Phone: 0300 123 6780  
Email: [developeras@lancashire.gov.uk](mailto:developeras@lancashire.gov.uk)  
Your ref: 3/2025/0989  
Our ref: 3/2025/0989/HDC/KW  
Date: 29 January 2026

**Location:** Land associated with 6 Top Row Sabden BB7 9HL  
**Proposal:** Proposed erection of No.4 detached garage buildings following demolition of existing garages on site.  
**Grid Ref:** 377735 437849

**Proposed Garages Layouts & Elevations for B**

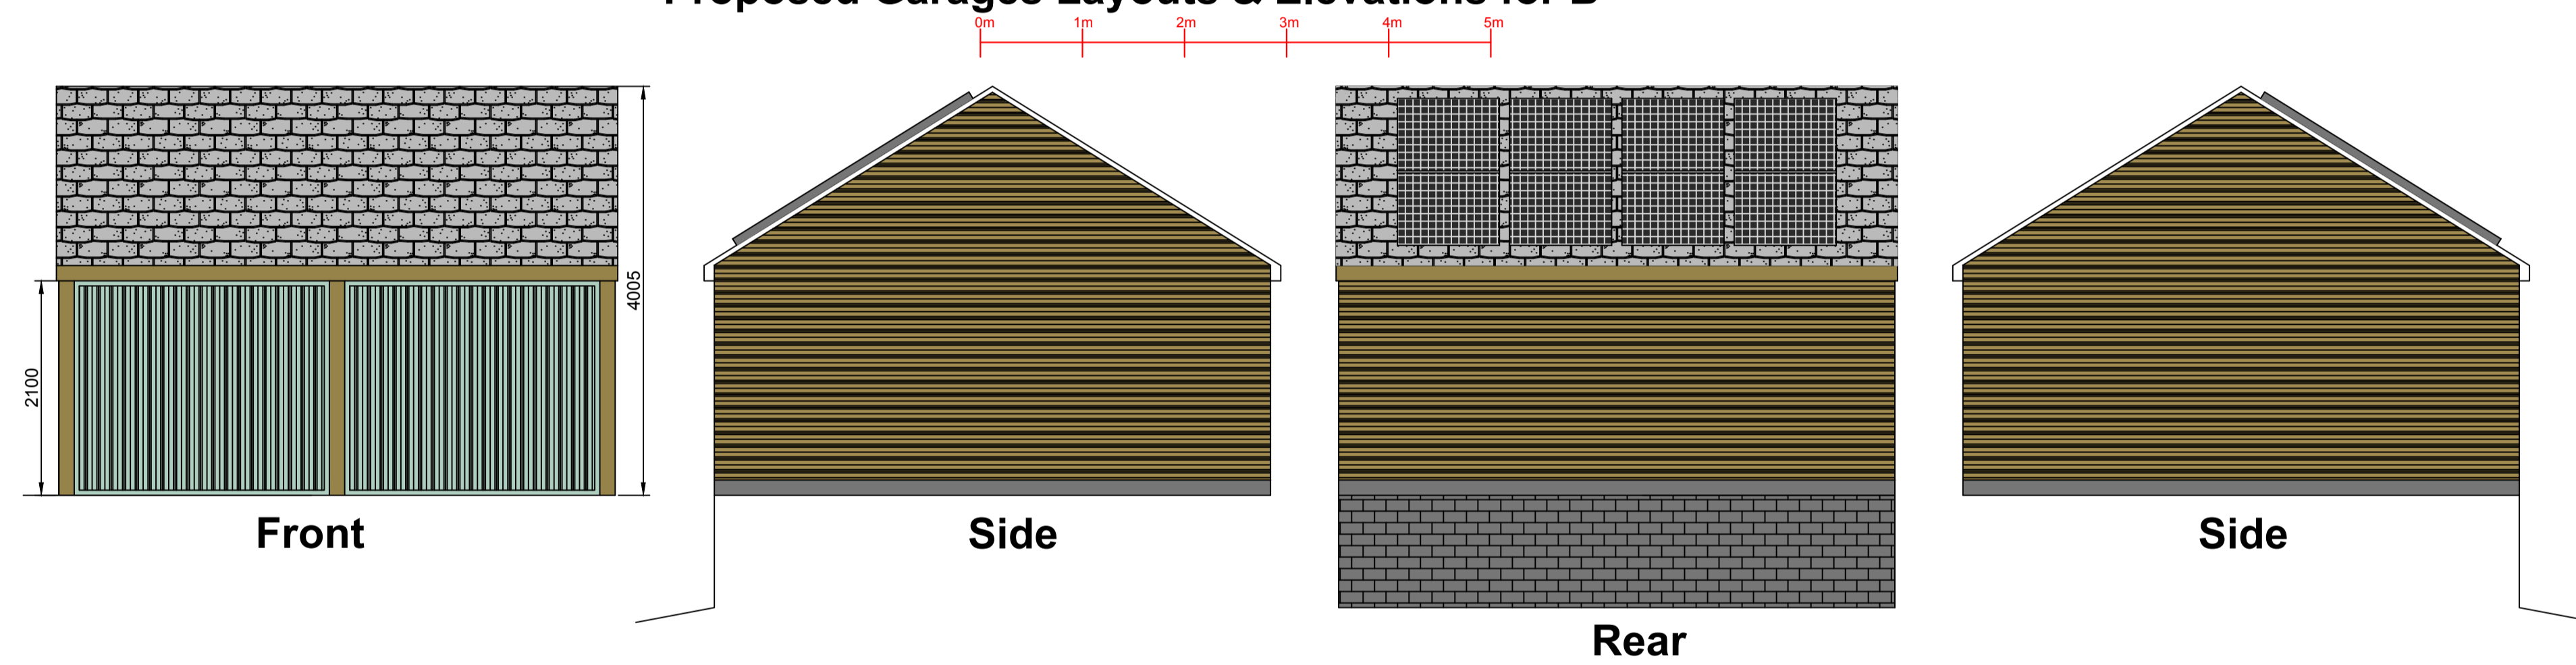
The recommended minimum internal dimensions for a double garage size is 6m in length and 6m wide. The recommended distance of 6m is based on the length of a large family car (Ford Mondeo Estate 4.58m long), clearance at the rear of the car (200mm), overhang of the garage door (600mm) and room to stand in front of the car and open/close the garage door (600mm).

As the proposed garages are smaller than the recommended minimum internal dimension of 6 x 6m they should not be counted as parking spaces. The LHA also expect the garages to be set back 6m from the edge of the private track so as not to cause an obstruction within the private track/public right of way.

Additionally, the proposed garage structures do not meet the recommended minimum internal dimensions of 6m by 6m.

Proposed Site Plan

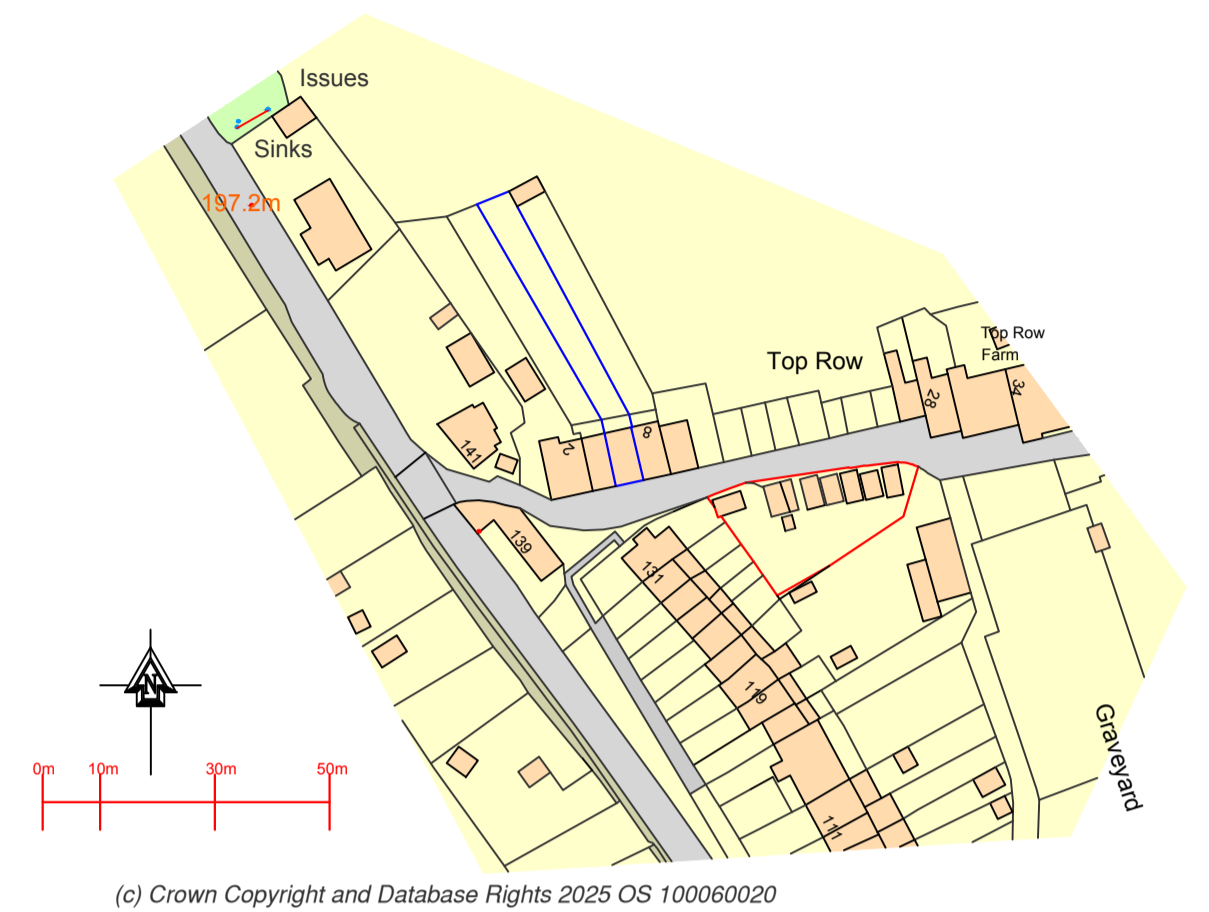
In summary, the Local Highway Authority considers that the proposed development, as submitted, does not adequately address the impacts associated with the site. The applicant will need to provide further information and revise the proposals to demonstrate appropriate set-back distances from the private lane.
